DELEGATED HOUSEHOLDER DECISION

77235/APP/2022/1373 - Erection of a single storey rear extension and conversion of roofspace to habitable use to include a rear dormer with a Juliette balcony and conversion of roof from hip to gable end. - Refused 22-06-22

An assessment of the plans and a site inspection has revealed that the main alterations between the as-built single storey rear extension (subject of this retrospective application) and the previously approved single storey rear extension (application reference: 77235/APP/2022/2138) can be

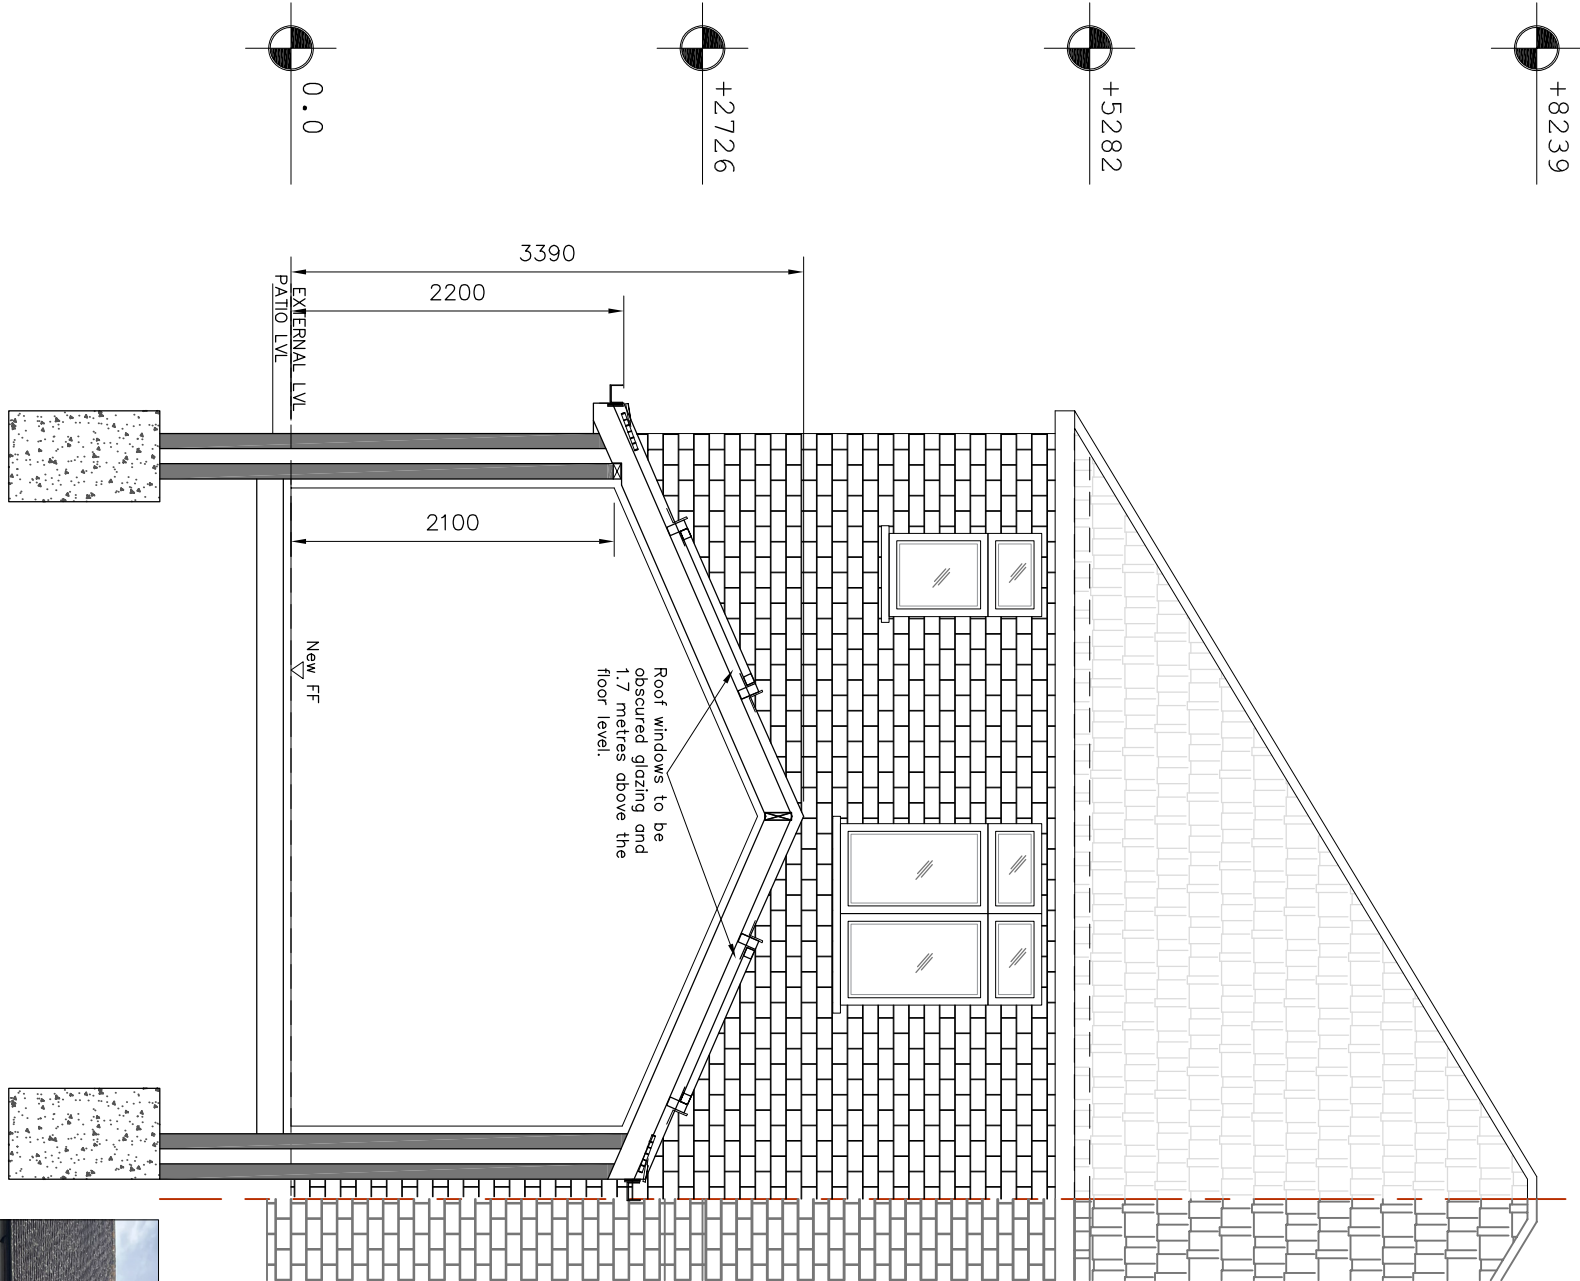
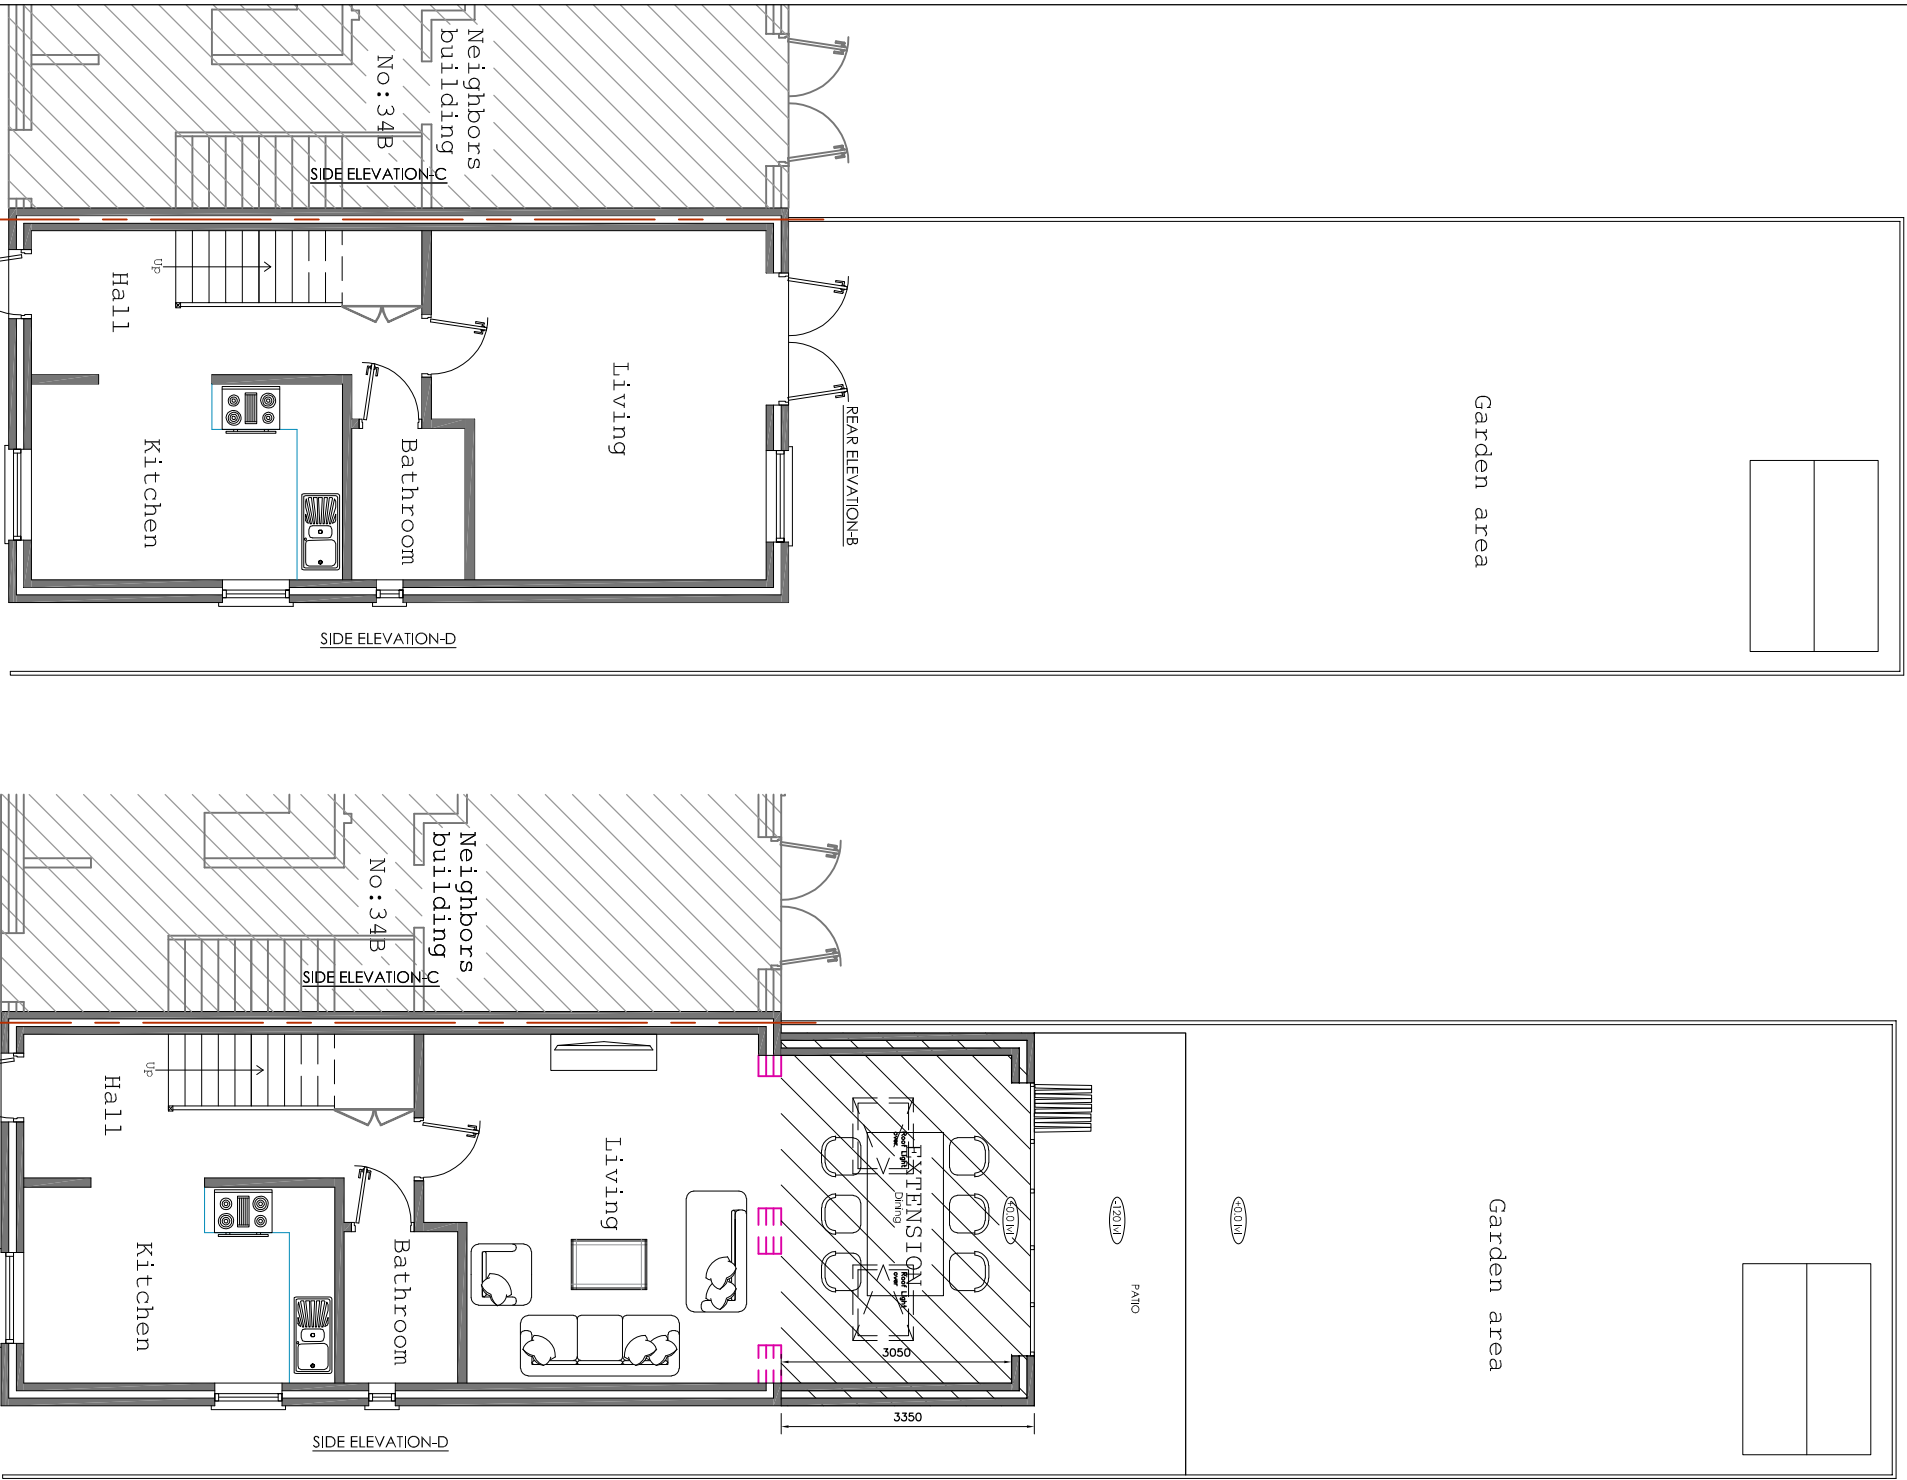
- Depth of the rear extension has increased from 3.3m to 3.35m;
- Eaves height has been increased from 2.25m to 2.4m;
- Maximum height of the pitched roof has increased from 3.15m to 3.54m and;
- Glazed panel below above bi-fold doors, replacing the approved brick work.

The existing rear building line of the application property is situated 1.34m beyond the rear building line of the neighbouring property 30D Northolt Avenue due to the staggered building lines. The proposed 3.35m deep extension, combined with the existing 1.34m projection beyond the neighbouring property, would result in the application property extending 4.69m beyond the neighbouring property. However, there is a separation distance of approximately 1.85m between the flank walls of Nos.30D & 34A Northolt Avenue. It is considered that this separation distance serves to mitigate any undue impacts from the development on the residential amenity of 30D Northolt Avenue. The proposed rooflight on the side of the pitched roof would be obscure-glazed and would be 2.6m above the finished floor level. Given the modest depth of the proposed extension, the modest height of the proposed dual-pitched roof ridge and eaves, the separation distance between the two properties, and the obscure-glazed side rooflight, it is considered that the proposed development would not adversely harm the residential amenity of 30D Northolt Avenue in terms of loss of light, outlook or privacy.

The development hereby permitted shall be retained and completed in accordance with the details shown on Drawing Nos. PE-02 Rev. C, PE-03 Rev. C & PE-04 Rev. C.
